A3
 SHEET 3 OF 5

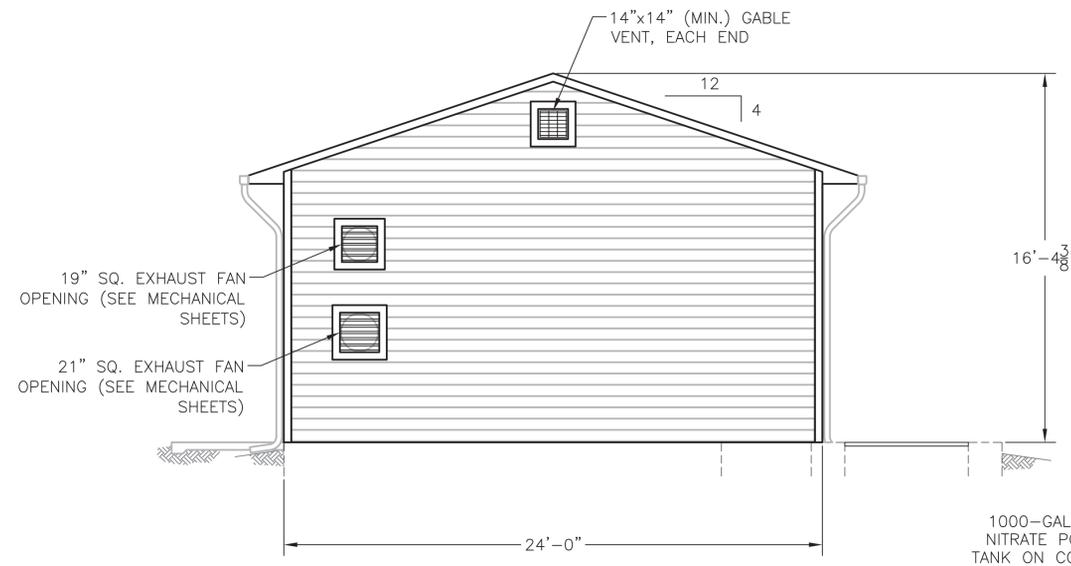
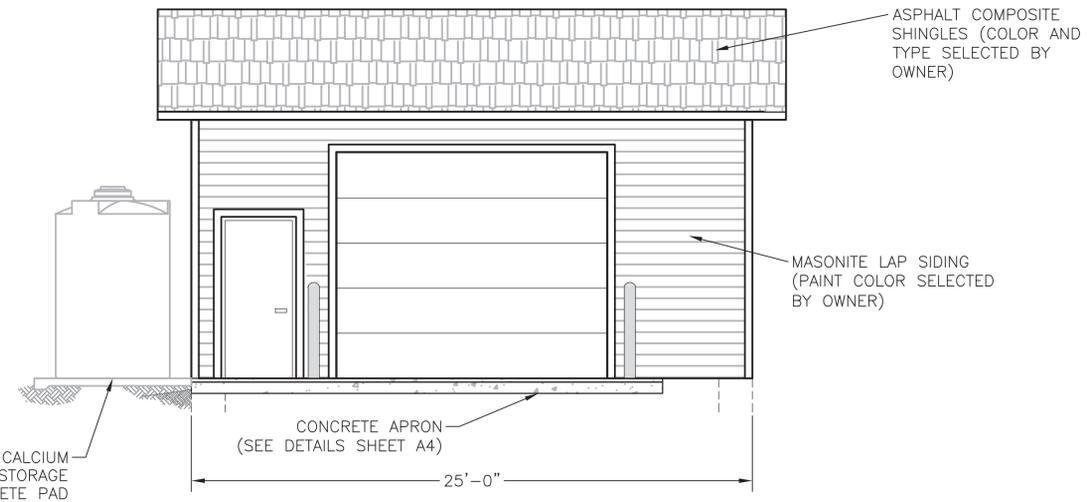
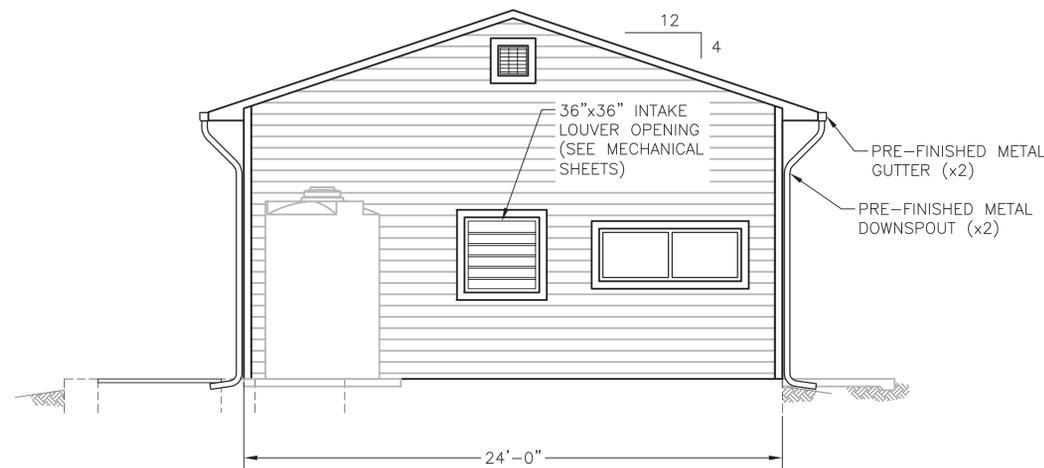
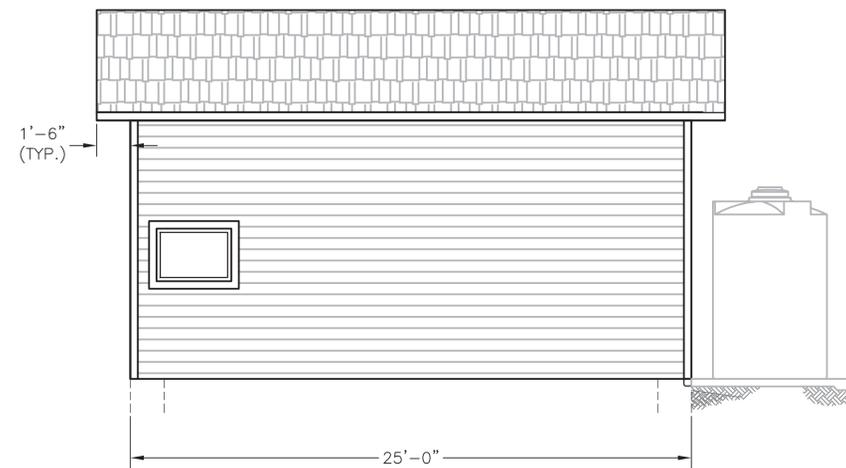
Building Elevations should show the dimensions of the structure.

Building Elevations should show the dimensions of the structure.
